TO: All Staff
FROM: Public Works Plan Review Team
DATE: June 2, 2021
SUBJECT: BL-21-00012 Niehoff

The Public Works Department has reviewed the Request for Boundary Line Adjustment Application. In order to ensure that it meets current Kittitas County Road Standards, the applicant needs to provide the following prior to final approval:

SITE PLAN

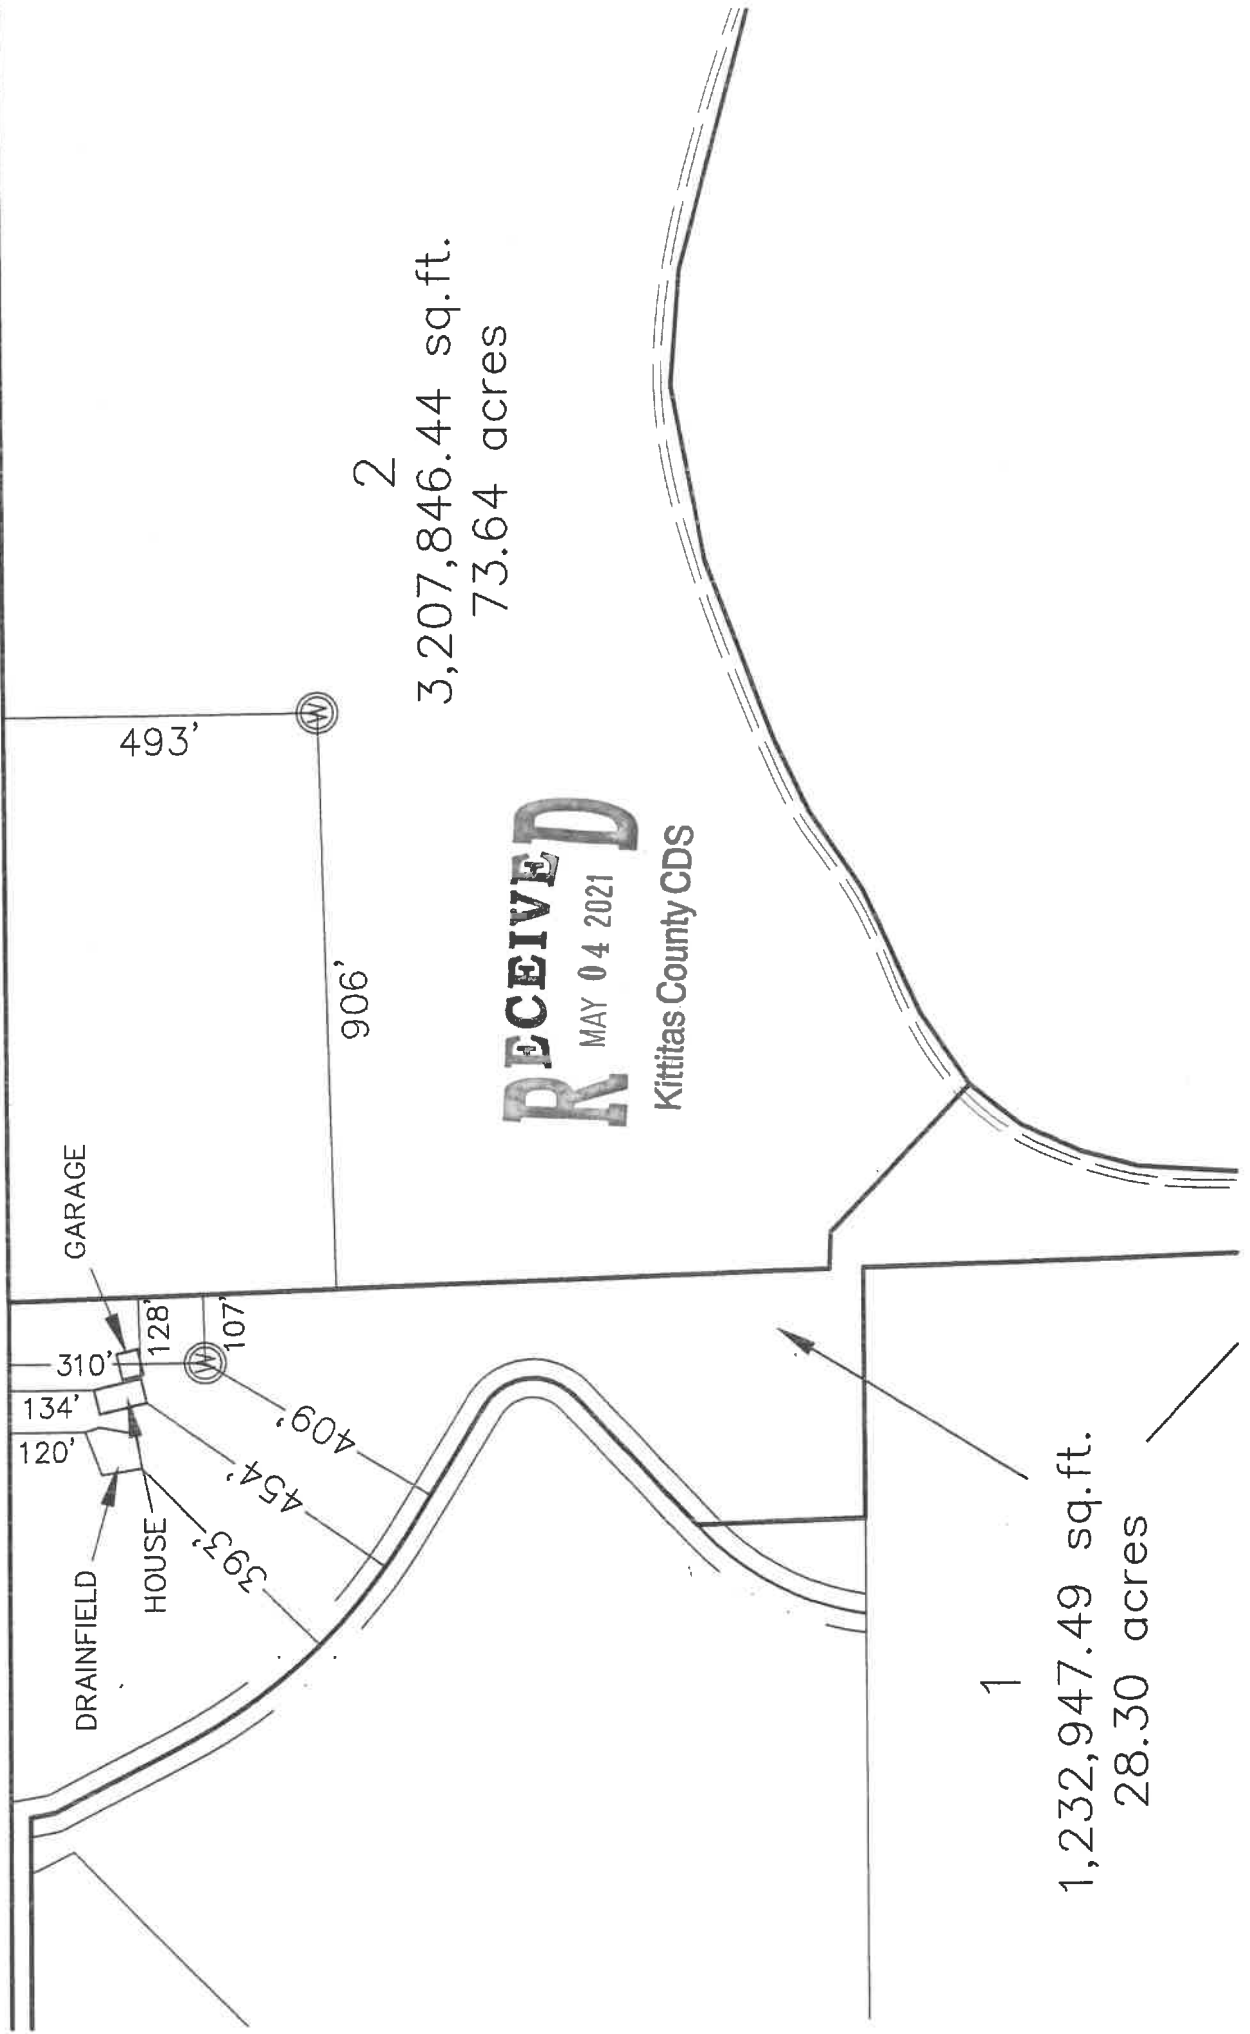
1. A revised legal description that describes the final configuration of the subject property shall be required.
2. A survey map for review. Any comments regarding survey will be reserved until final.
3. Please provide proof of legal access for TPN830733. No easement is shown in previous surveys for the existing road along the northern lot line of TPN 956155.
4. Show access easements on the face of the BLA.
